Applicant: Mrs I Wainwright

Description: External works including additional parking area, new patio, new pathways, planters and raised decking area External works including additional parking area, new patio, new pathways, planters and raised decking area (Listed Building Consent)

Site Address: The Granary, 3 Fieldhead Manor, Elmhirst Lane, Dodworth, Barnsley, S75 4LD

DRAWING NO. 0014-115 REVISION A
 SCALE 1:100 @ A2 DATE NOV '21
 DRAWN BY JC CHECKED BY -

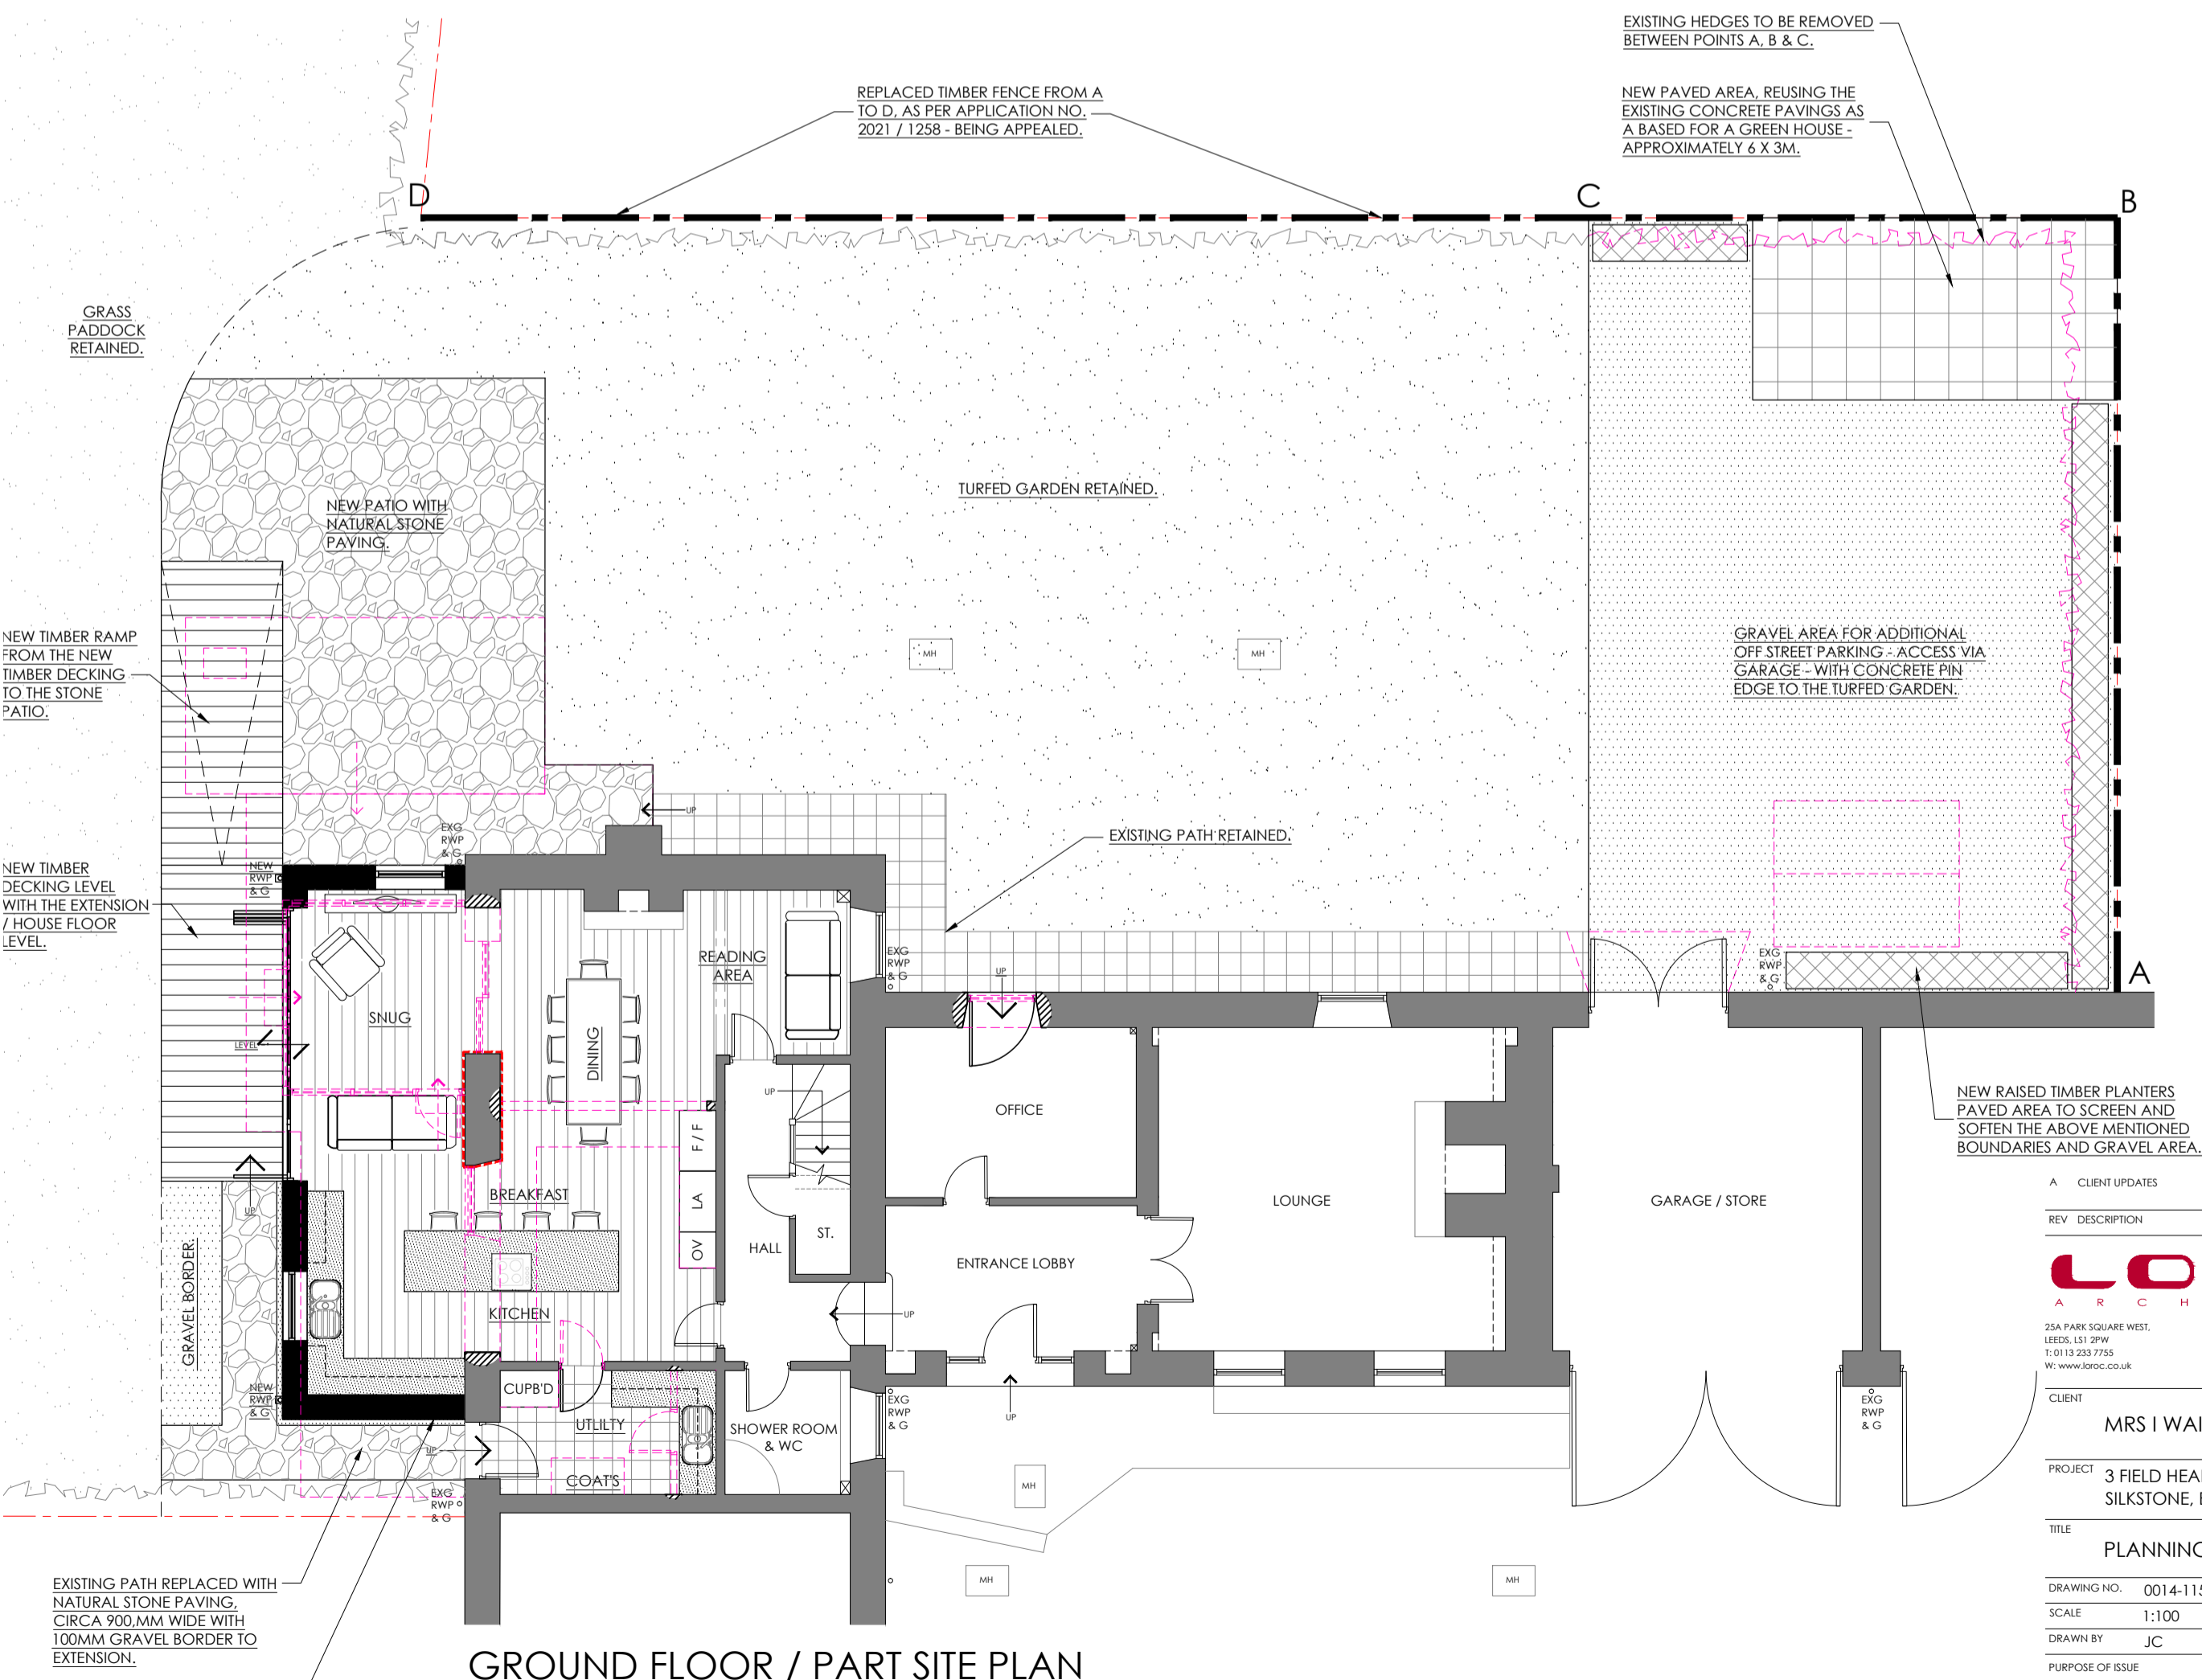
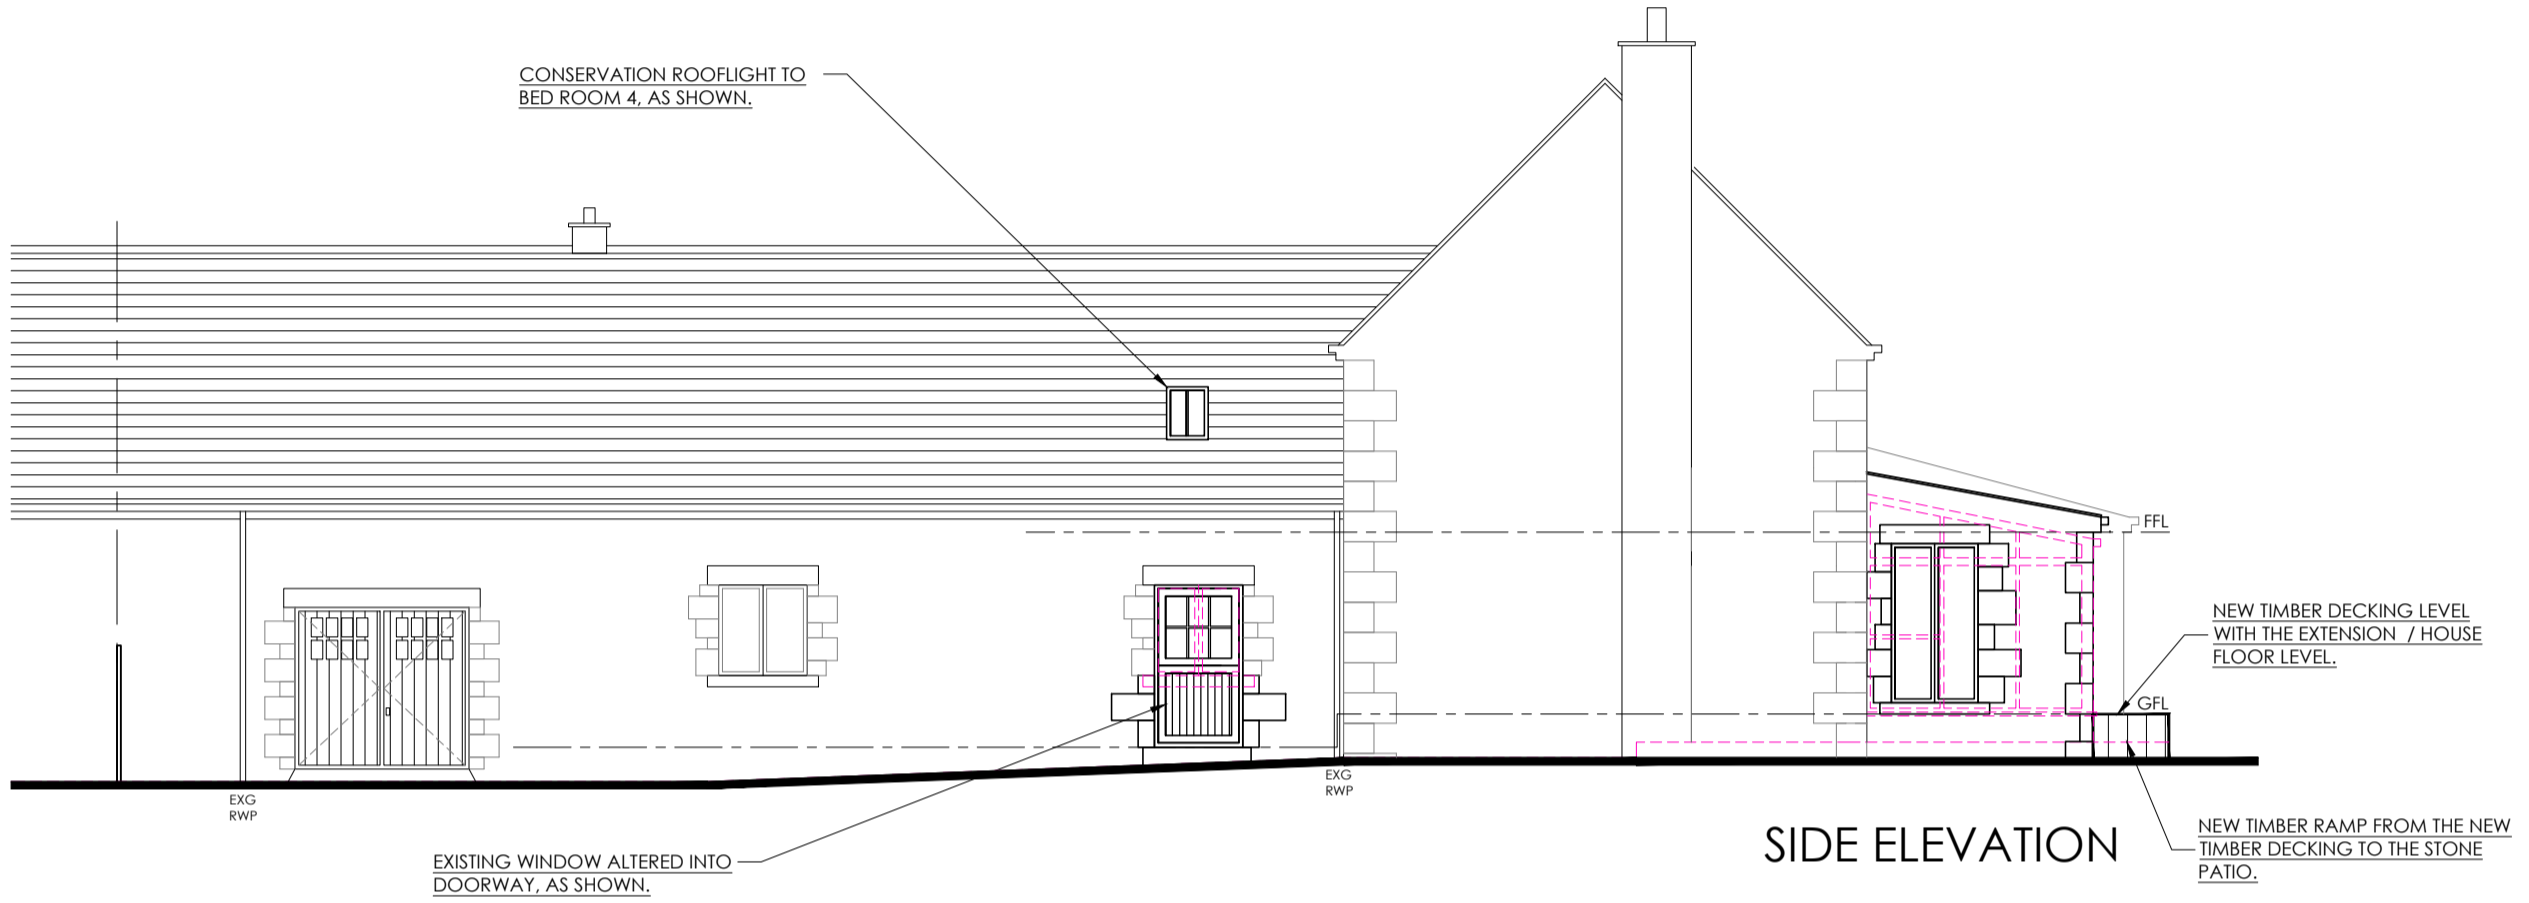
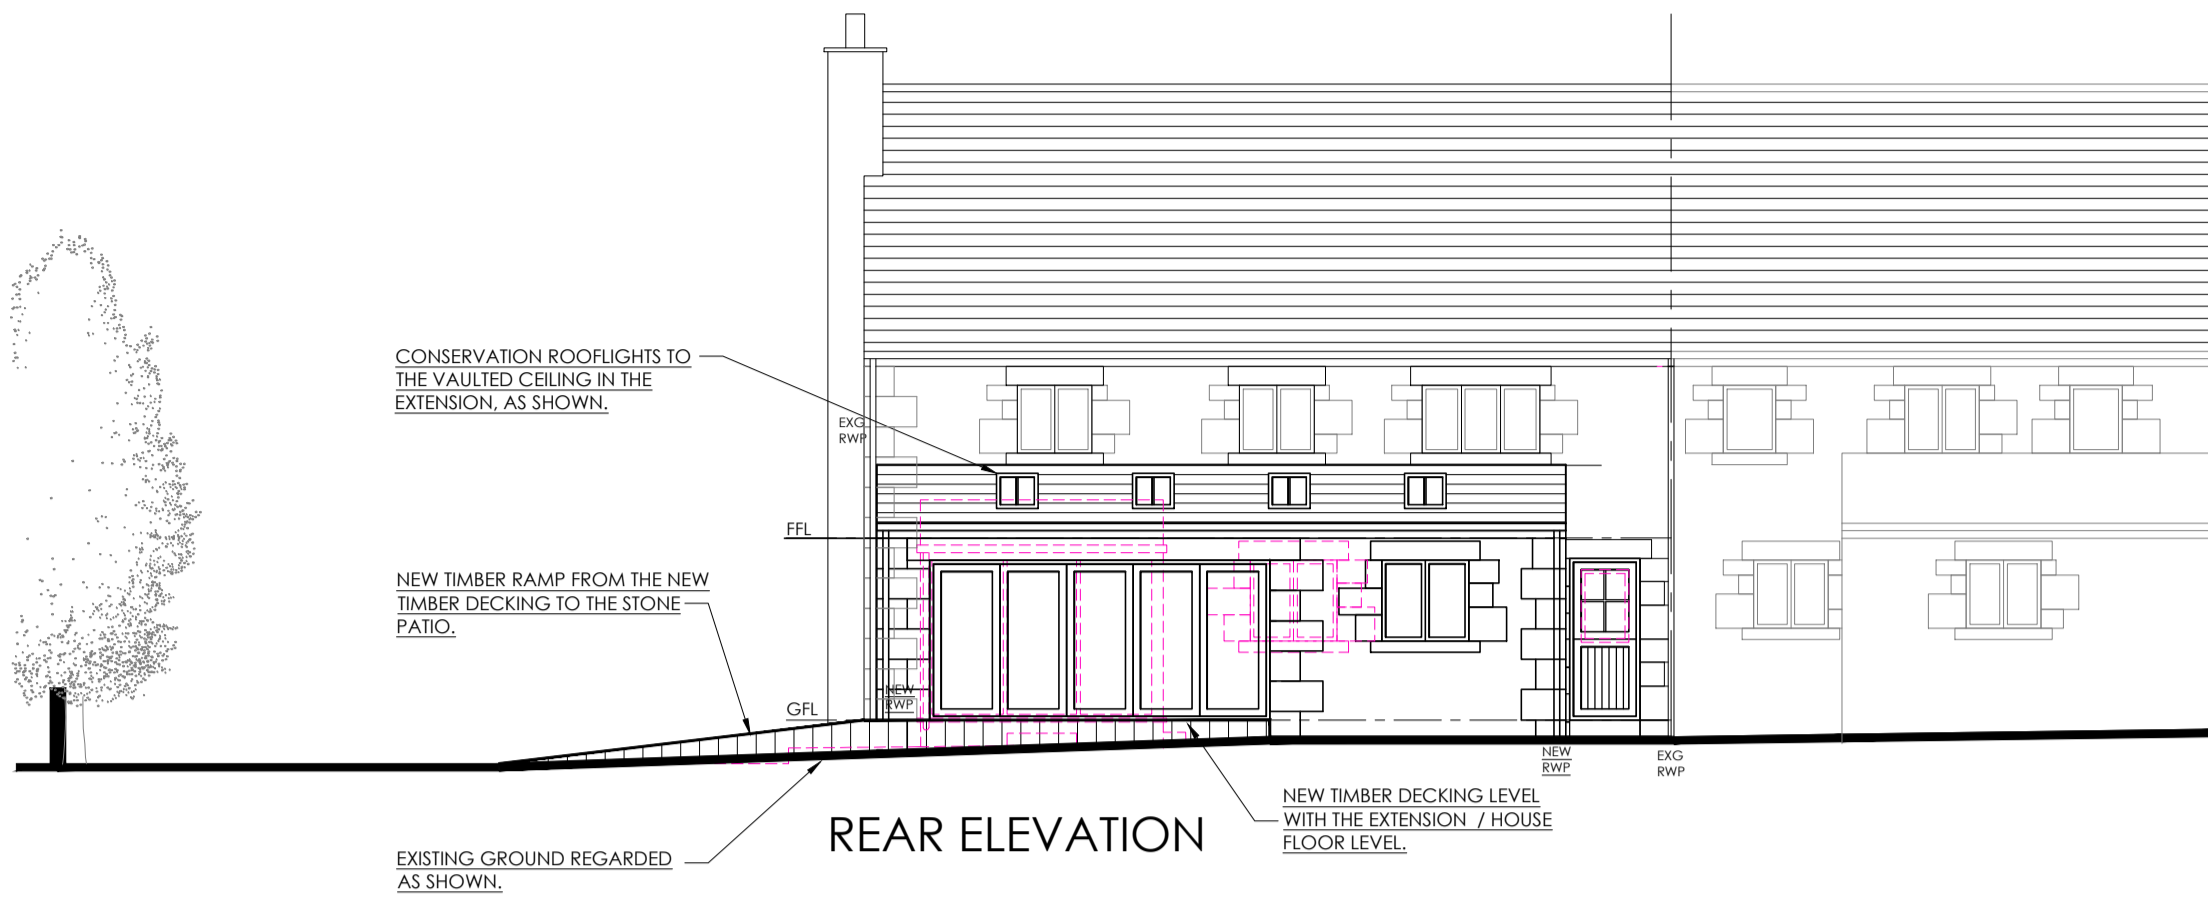
I note where there are currently lawns and grassed areas these will become either an area of decking, stone, or gravelled areas. This will introduce a degree of increased domestication to the character of the setting. I also believe the area of paving to accommodate the greenhouse is within an area of recently installed fencing. This proposal includes plans to remove the hedging in this area. However, I understand the application to approve the fence that was recently refused is to be appealed. As such, whilst we cannot control the removal of hedging under the Listed Buildings and Conservation area Act, I would have to say I do not support the removal of the hedge to accommodate the fence which is to be appealed. Even so, in regard to the rest of the proposal I feel there is little harm due to the low degree of upstand of the decking (nil to the other areas), and the relatively sympathetic materials. Consequently, I feel this will not be overly intrusive and on balance I support.

One matter worthy of clarification would be the materials proposed for the works to the patio, gravelled area, and decking. If we could clarify the exact nature of these (perhaps by photos or samples) that would avoid the need for a condition to discharge those details.

The agent was requested to provide details of the materials upfront but no information was forthcoming, as such, the materials will be conditioned.
